**Application to Discharge Conditions attached to Listed Building Consent 92/03645/LBA
The Horse Shoe Bar, 17-19 Drury Street, Glasgow, G2 5AE**

We are pleased to enclose details to discharge conditions 01, 03 and 04 of listed building consent 19/03645/LBA dated 14th May 2020.

JOB TITLE	DATE	SCALE	DRAWING NO.
MITCHELLS & BUTLERS THE HORSE SHOE BAR GLASGOW	22.11.19	1:50 @ A1	JMDA 1486/105B
DRAWING TITLE: PROPOSED WALL FINISHES / CURTAINS			
NOTE: THIS DRAWING TO BE PRINTED IN COLOUR FOR CLARITY			
DRAWN BY: ES		DRAWING NO: JMDA 1486/105B

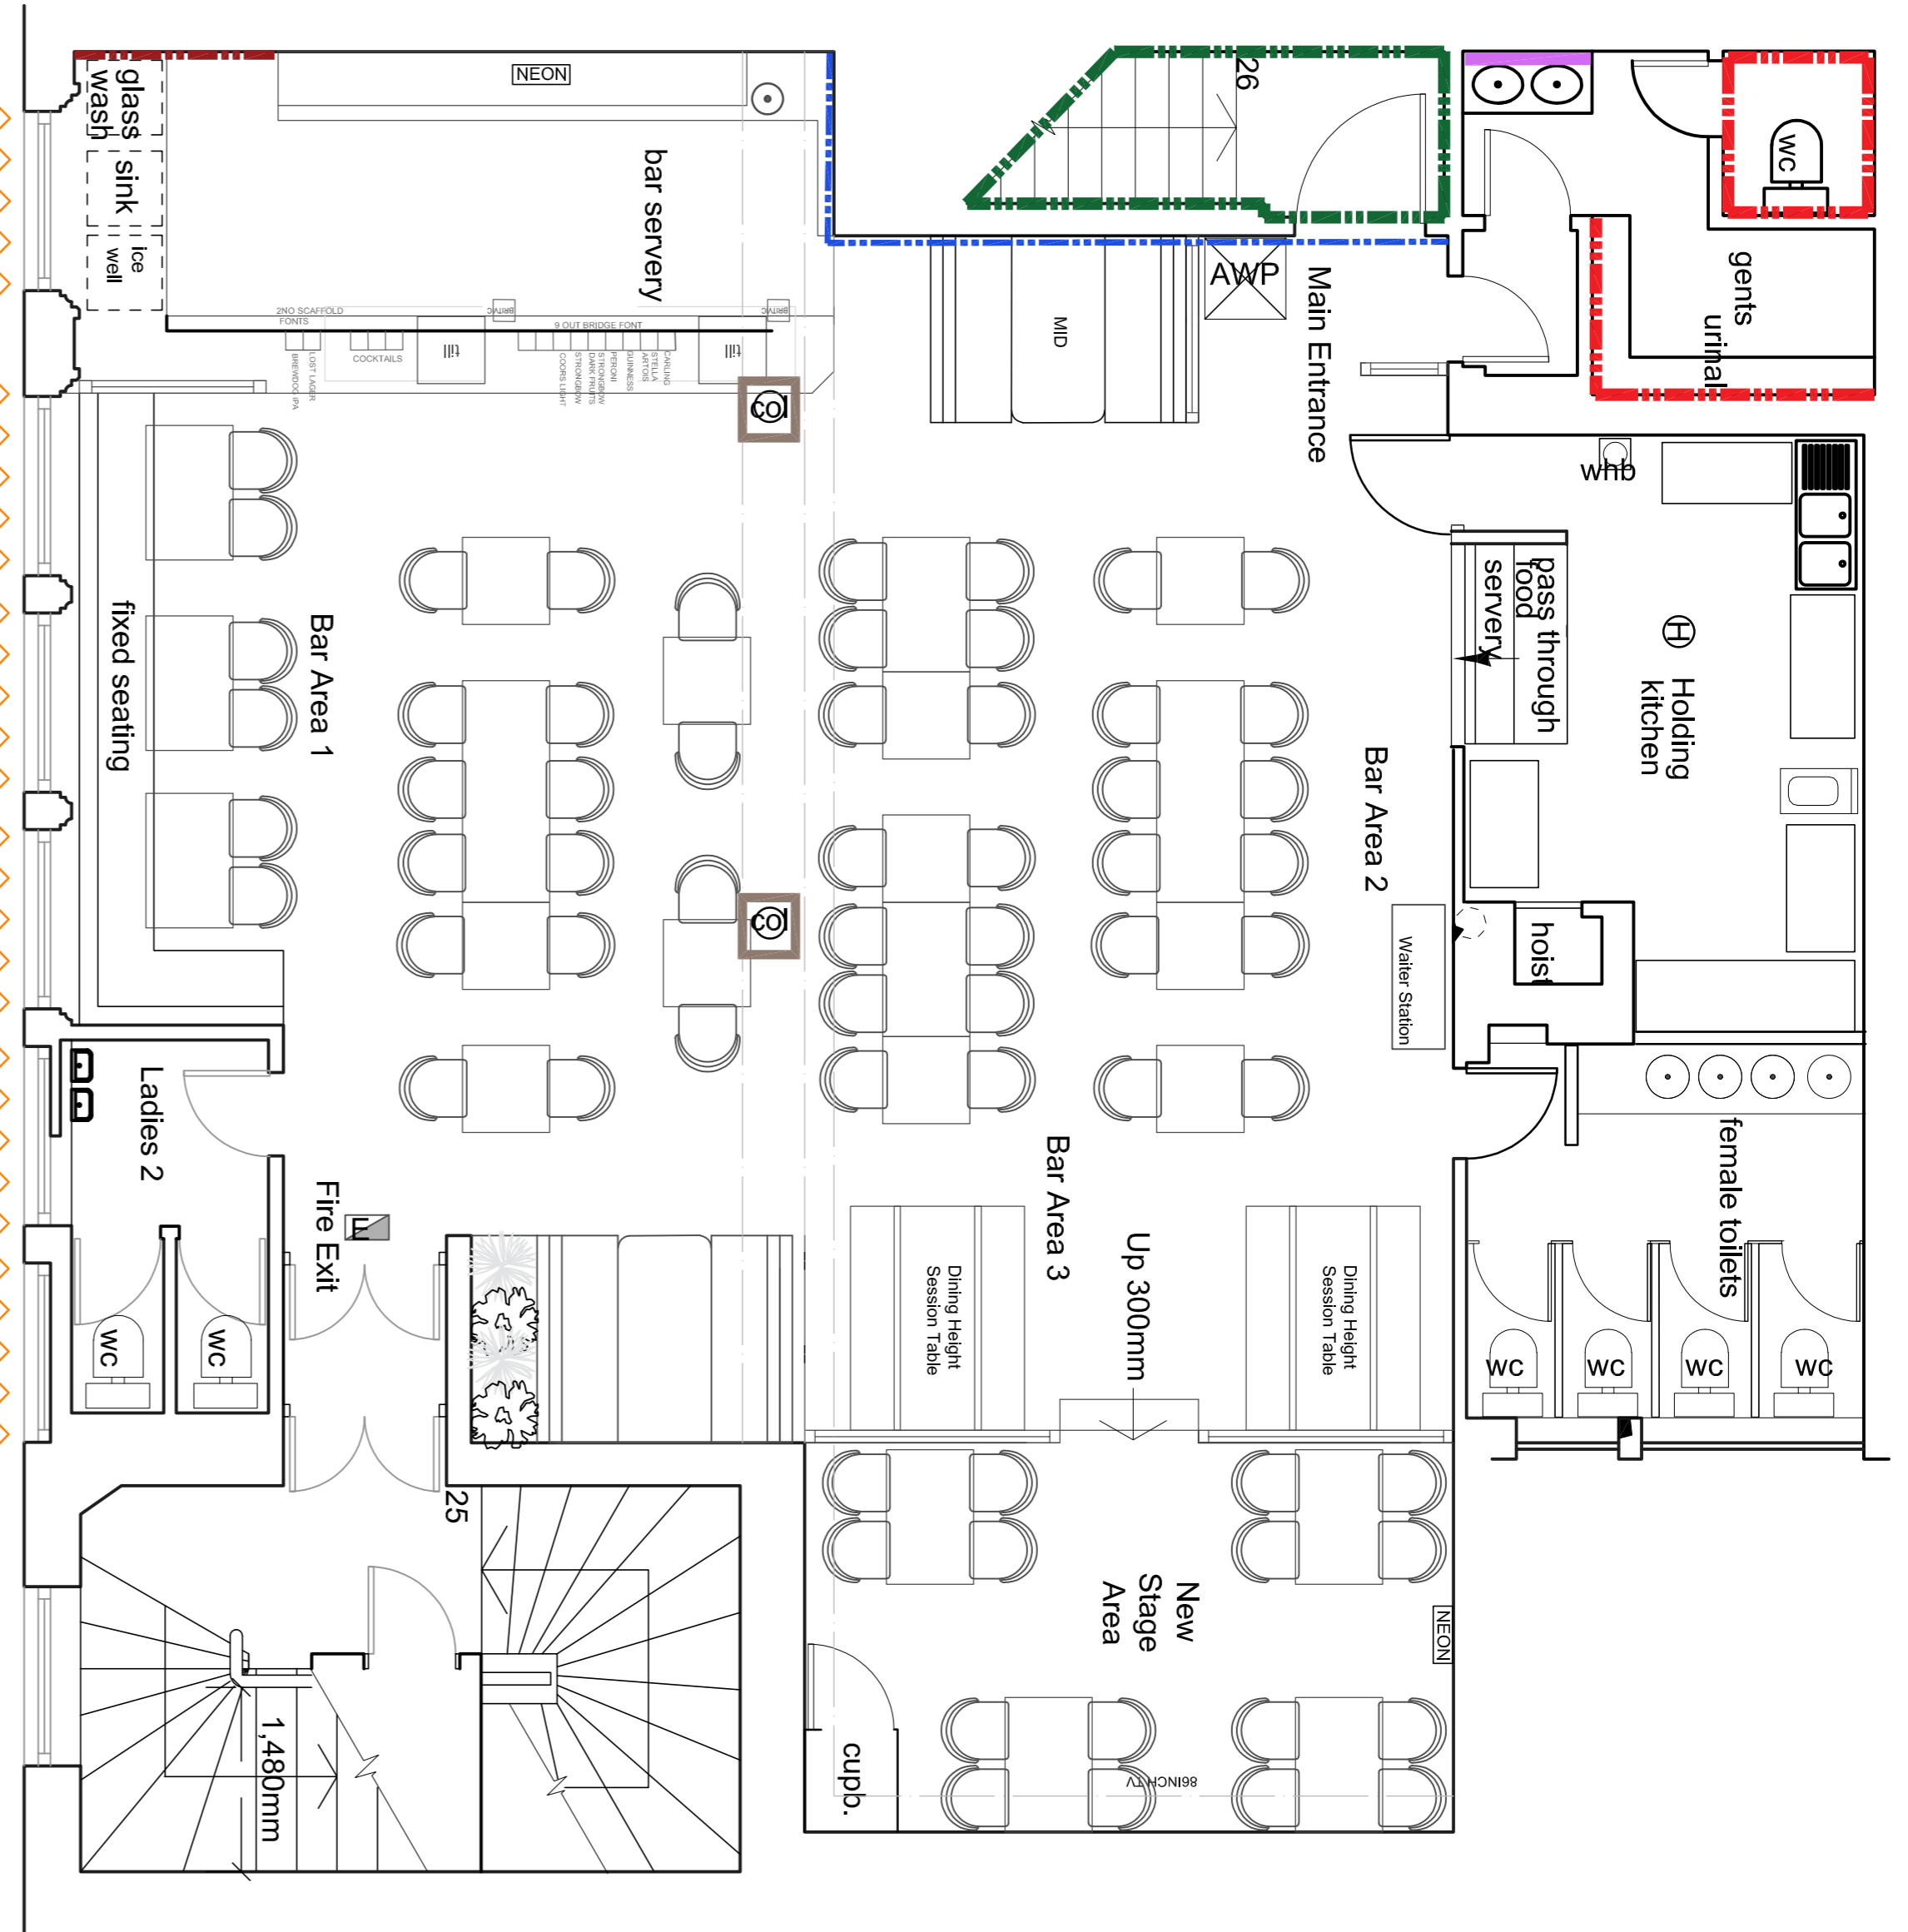
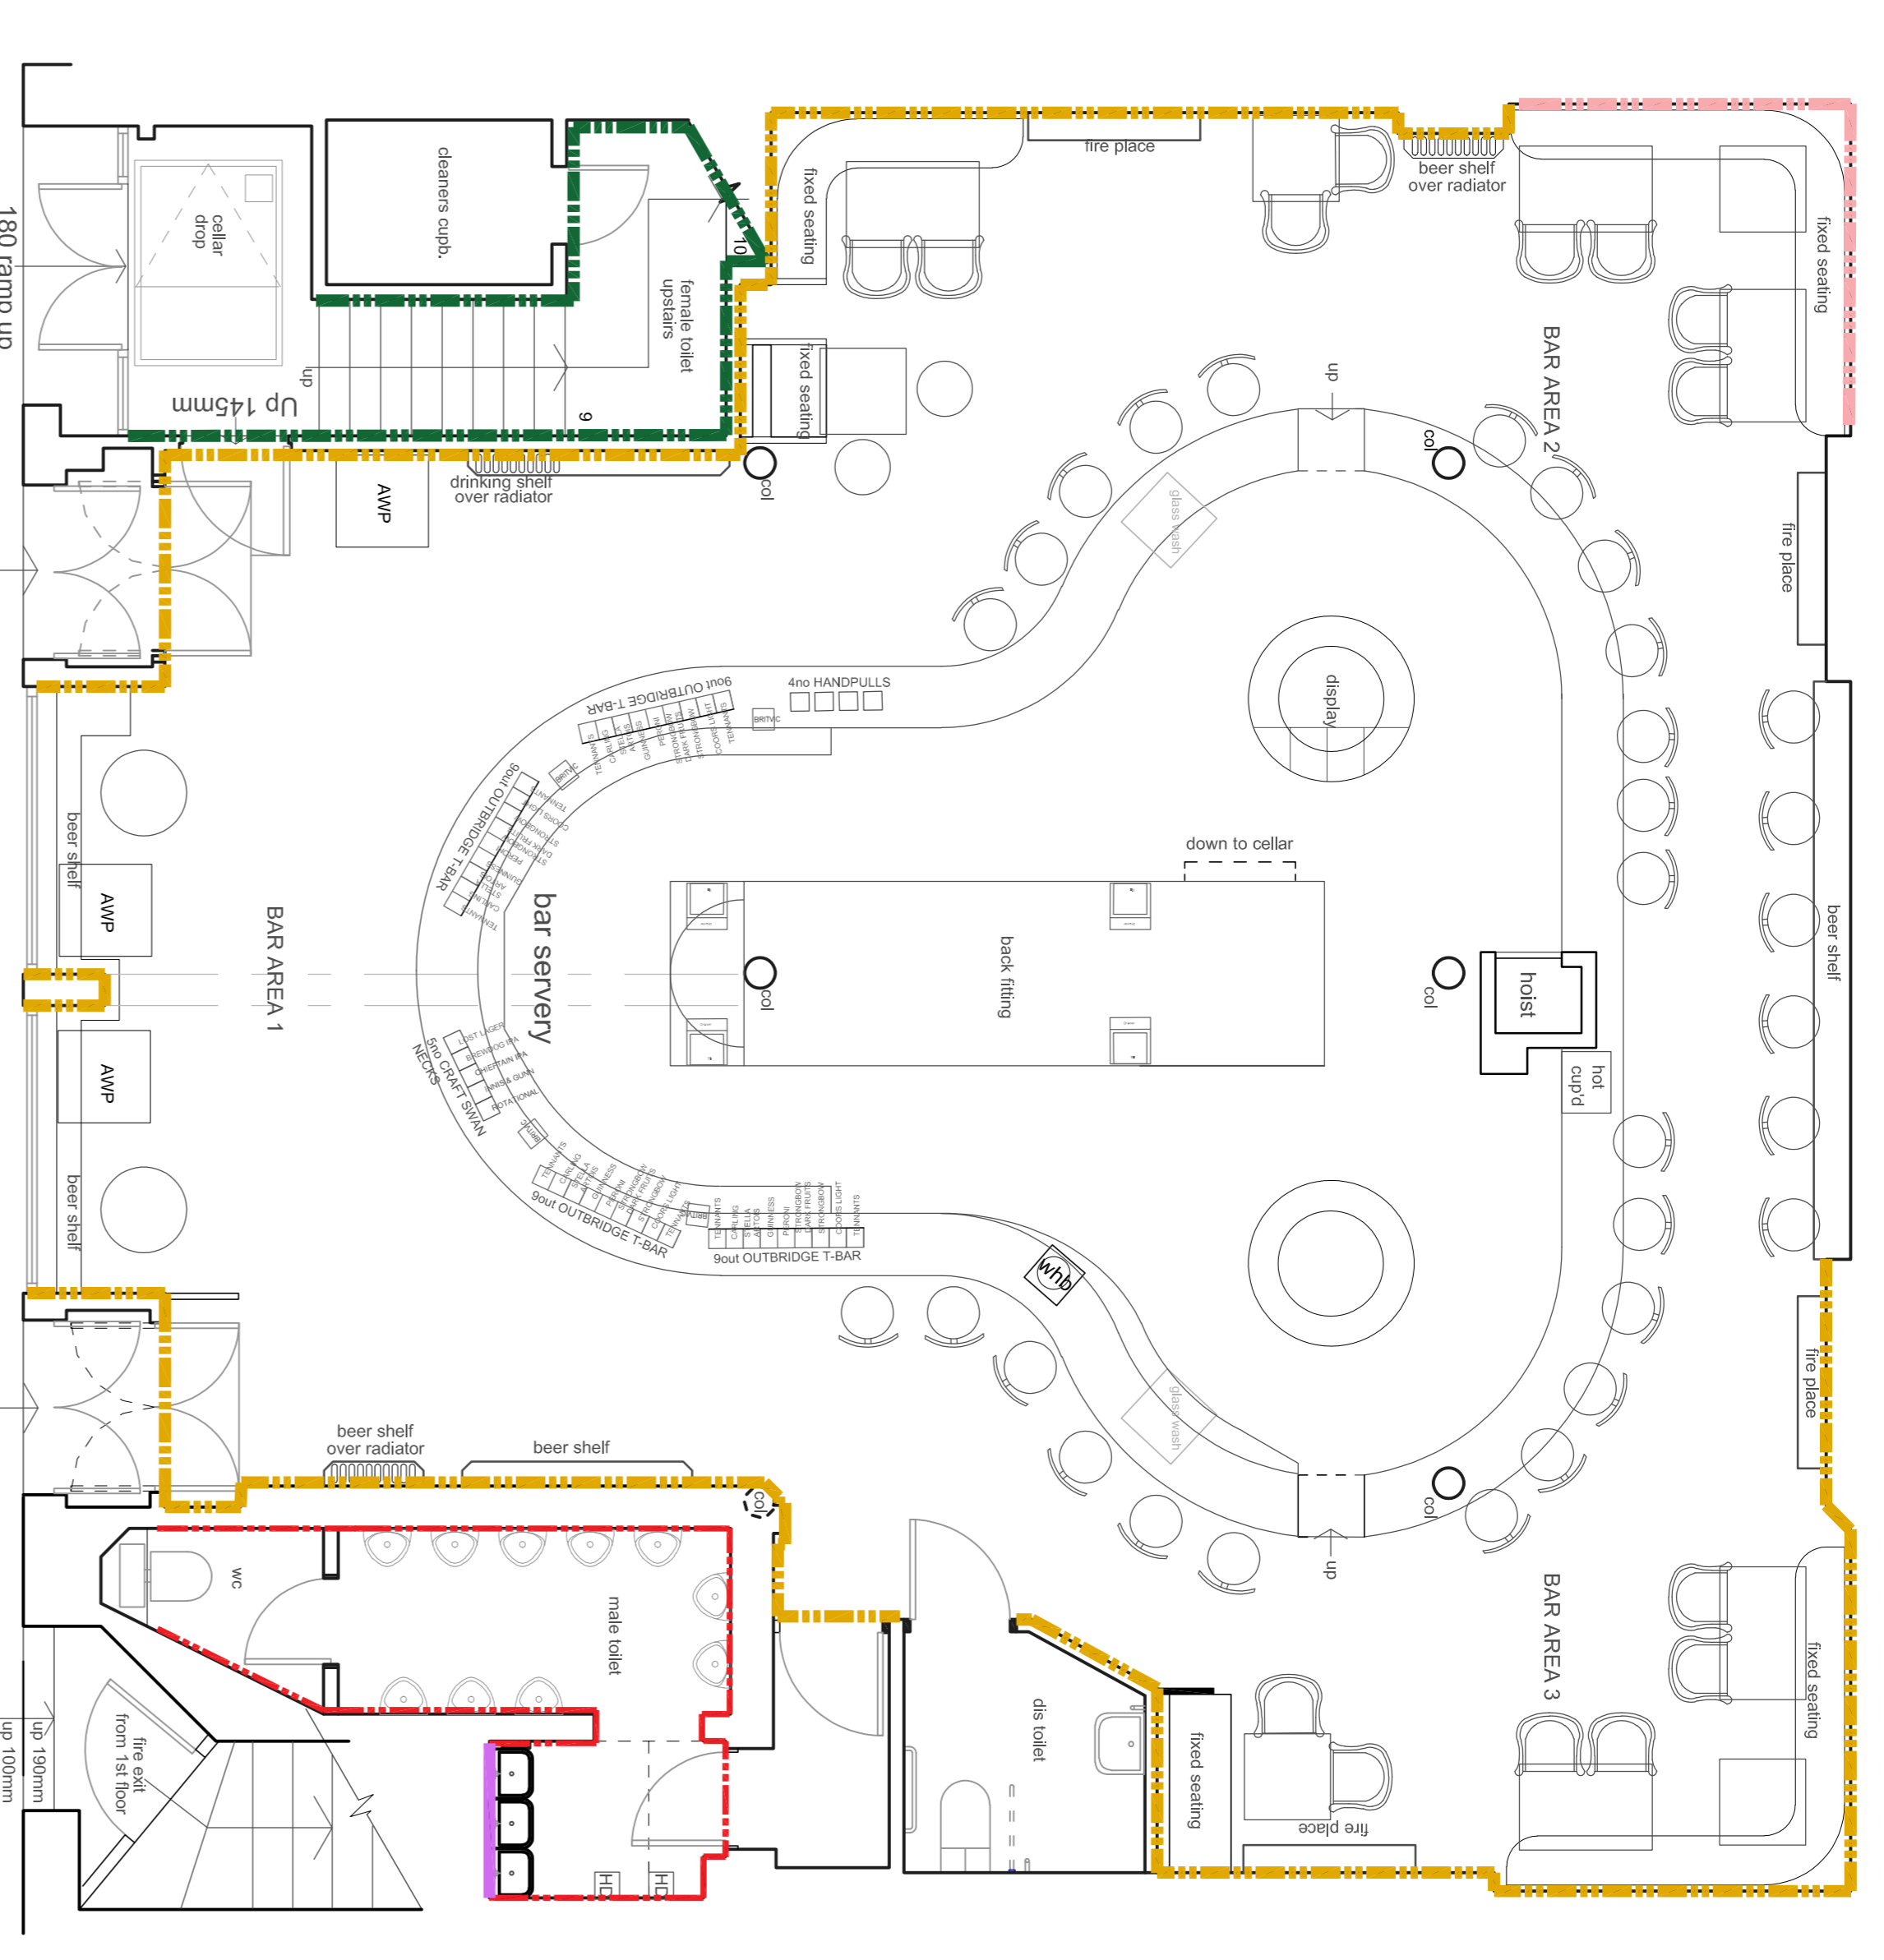
I would also encourage the applicant to reconsider the proposed use of brick slips for the wall behind the bar and the stage area at first floor, with this industrial aesthetic not being particularly sympathetic to the richly decorative wall and ceiling finishes elsewhere. Furthermore the removal of the picture rail should be resisted.

"For the avoidance of doubt, the proposed wall coverings to the first floor are hereby not approved. Revised scheme of decorations for the first floor area shall be submitted to,

and approved in writing by the Planning Authority prior to this element of work commencing”.

The main issue, in this respect, concerned the ‘perceived industrial aesthetic’ of the decoration scheme. The scheme has been revised and is detailed on Drawing 1486/105B: Proposed Wall Finishes.
